Flood Management Consultation

Consultation on Application Number: 2017/62/90255/E

Address: 15, Lower Lark Hill, Moorbottom, Cleckheaton, BD19 6JJ

Proposal: Erection of one dwelling and demolition of outbuildings

dwg:
Existing & Proposed
Site Plan & Sections

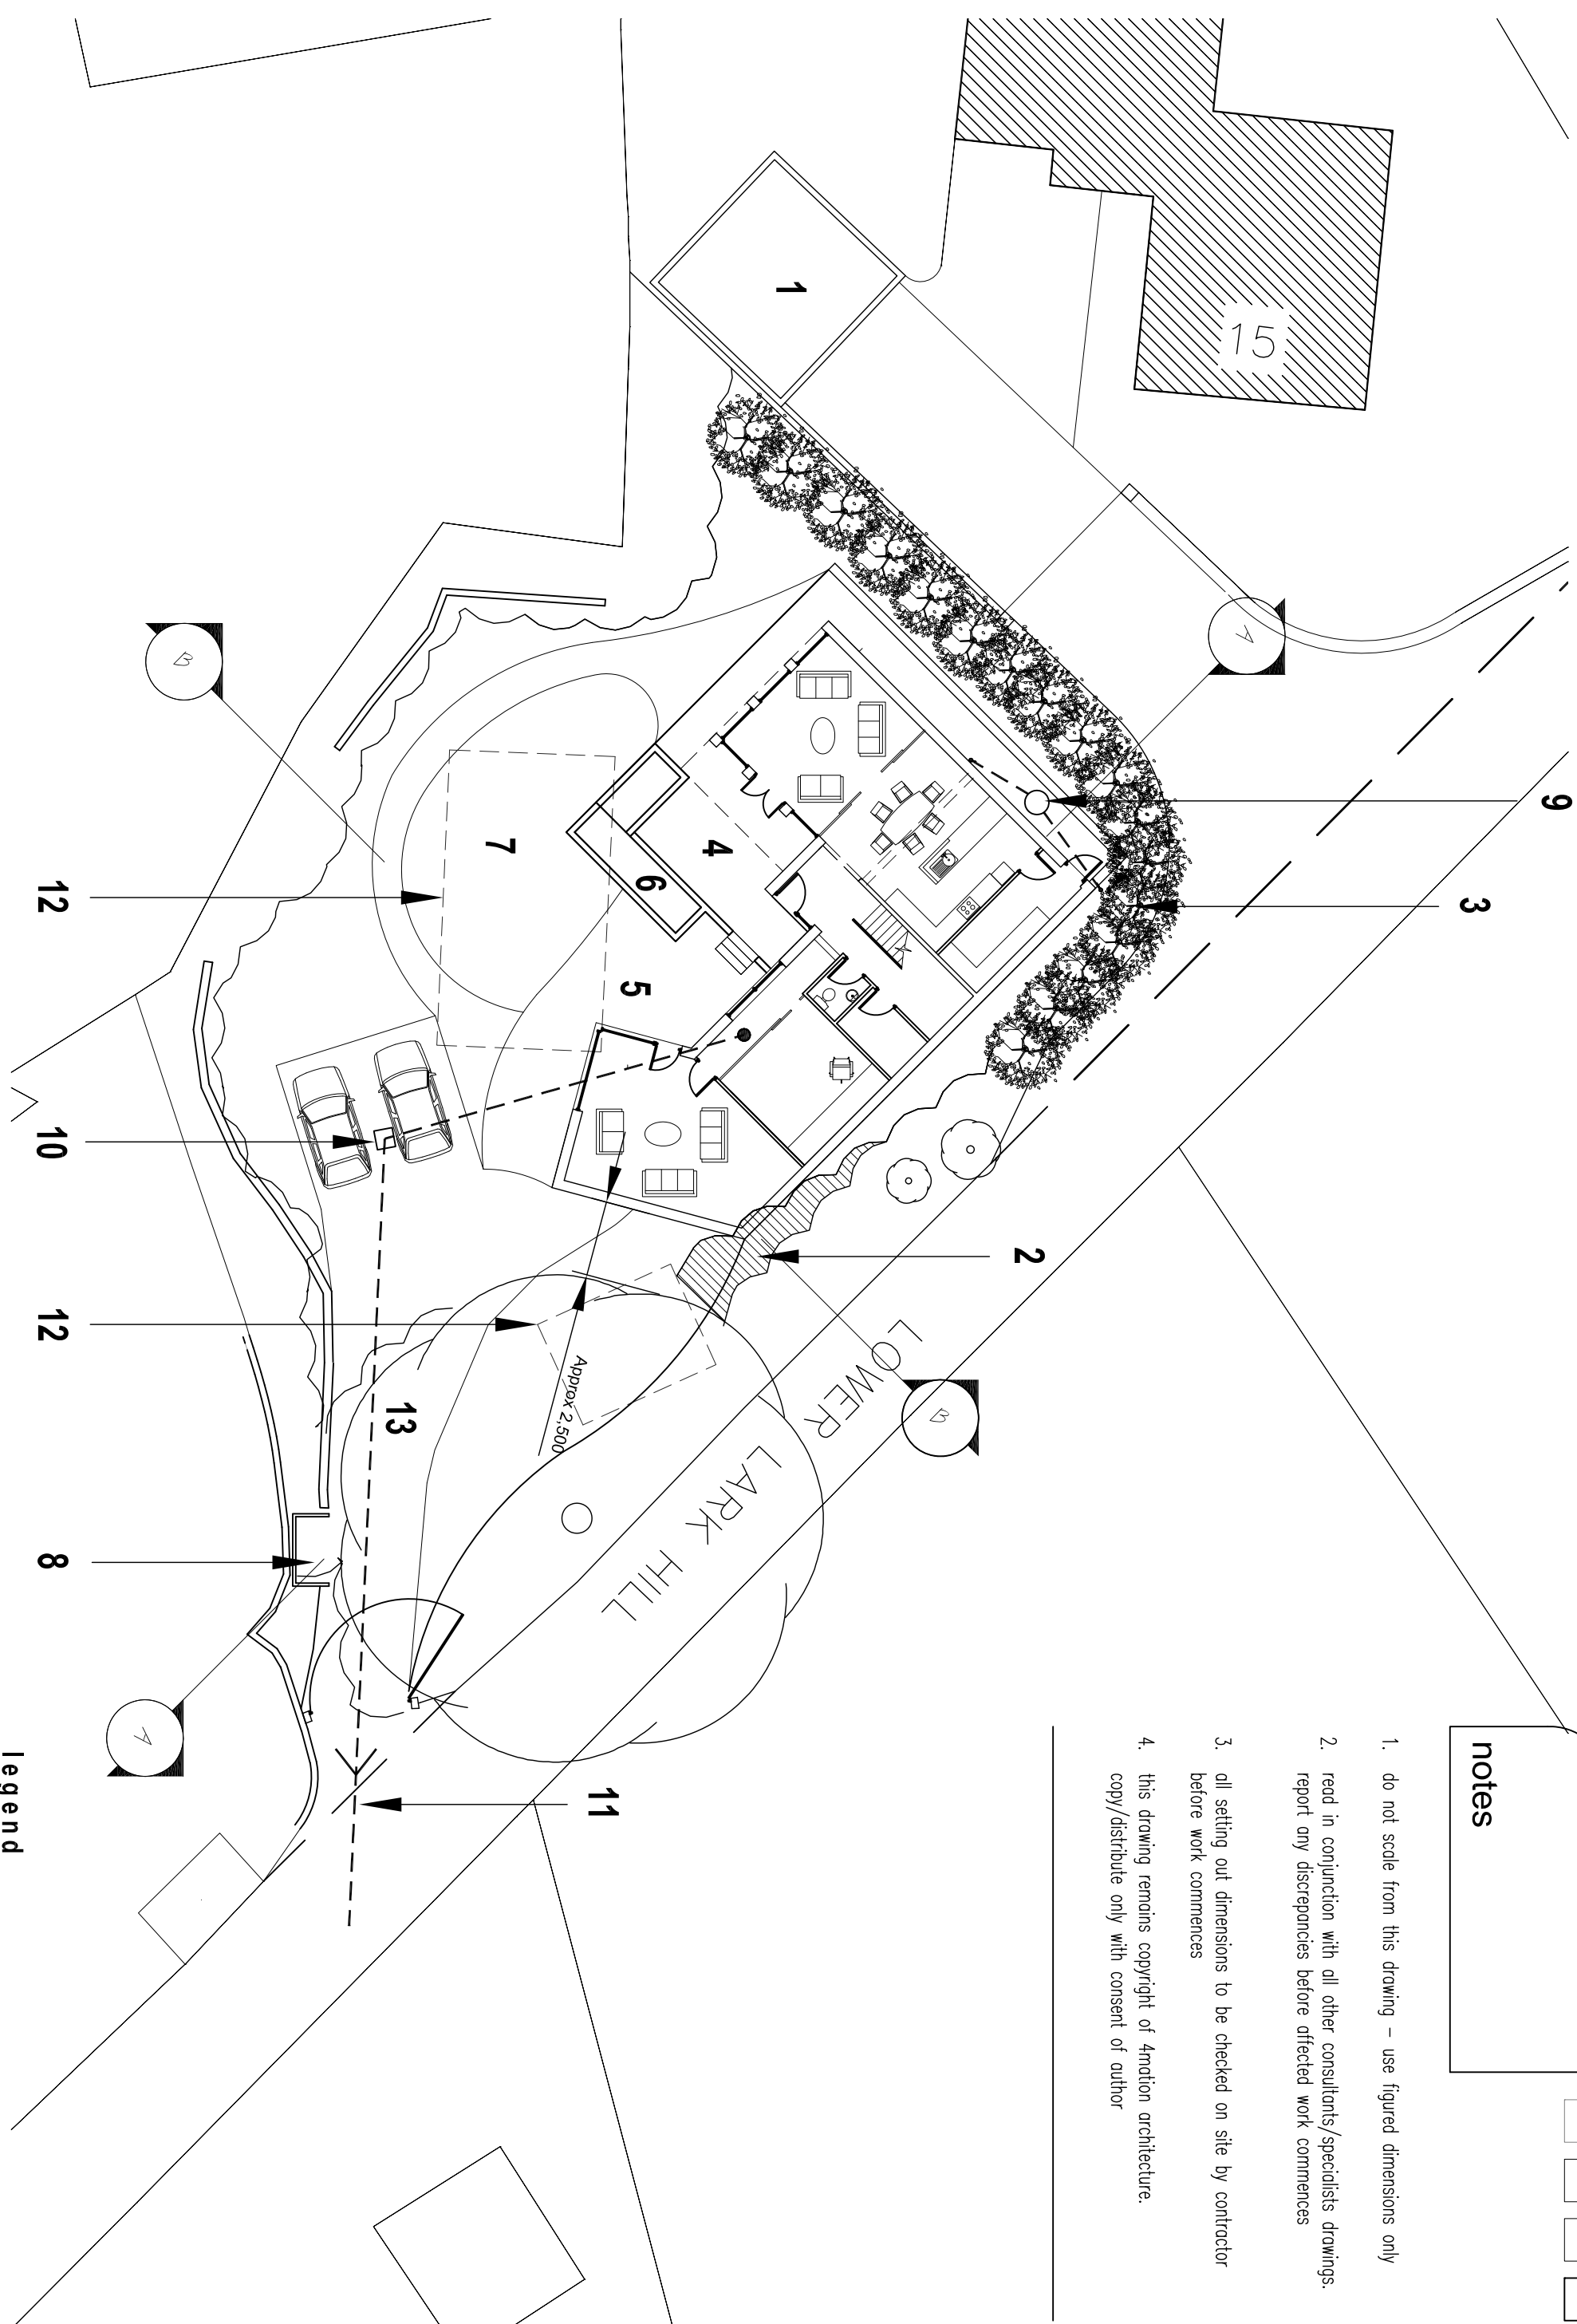
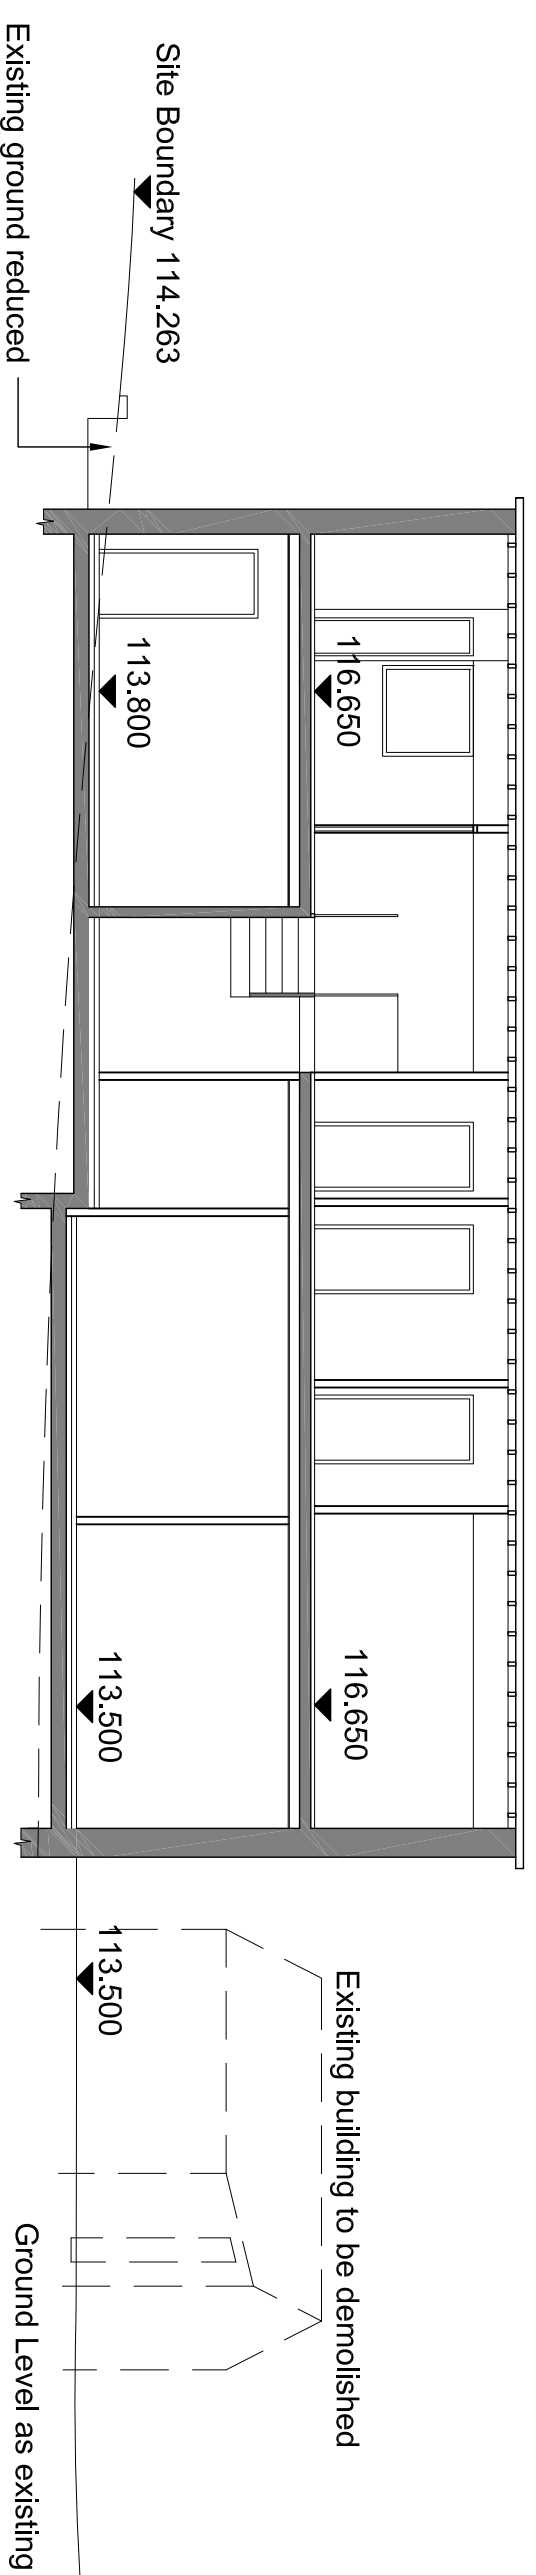
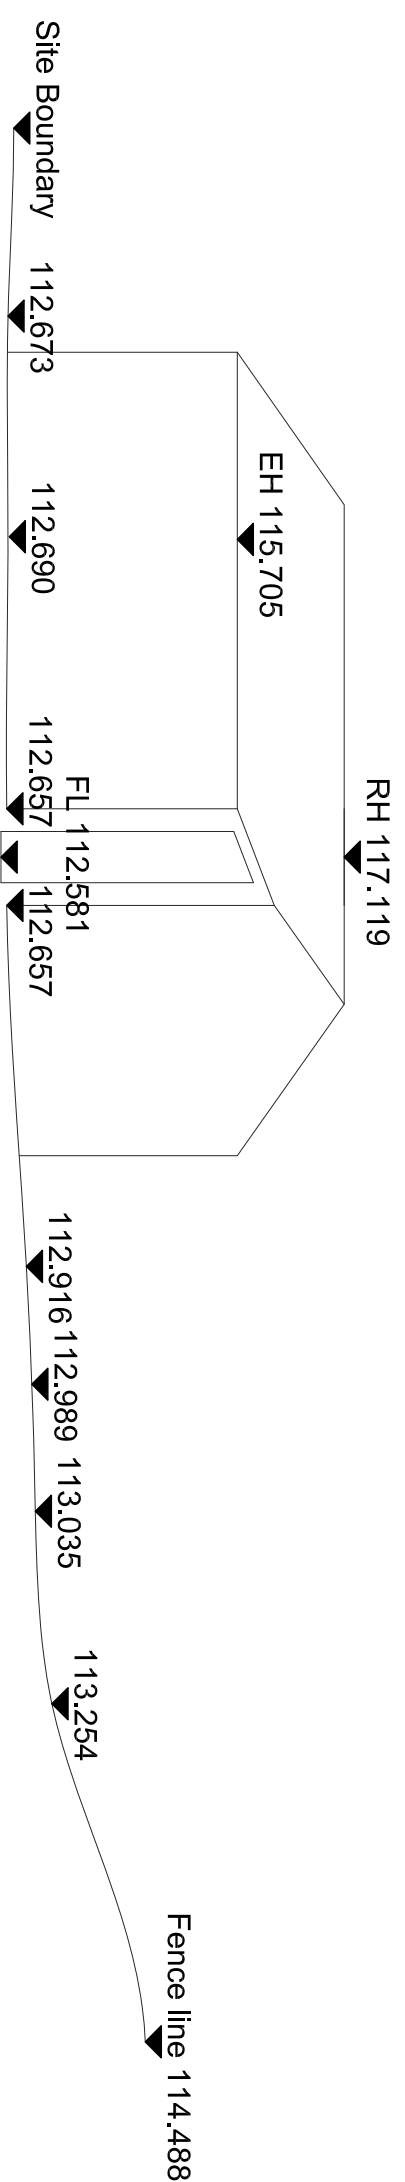
The site is shown to be at risk from surface water flooding with depths of over 1.2m possible in places. Although the proposed floor plan has a note on it to say the finished floor level of the property has been raised to accommodate flood risk, the supporting assessment of flood levels has not been submitted.

This information must be submitted as part of this application, in particular as bedrooms are proposed at ground floor level.
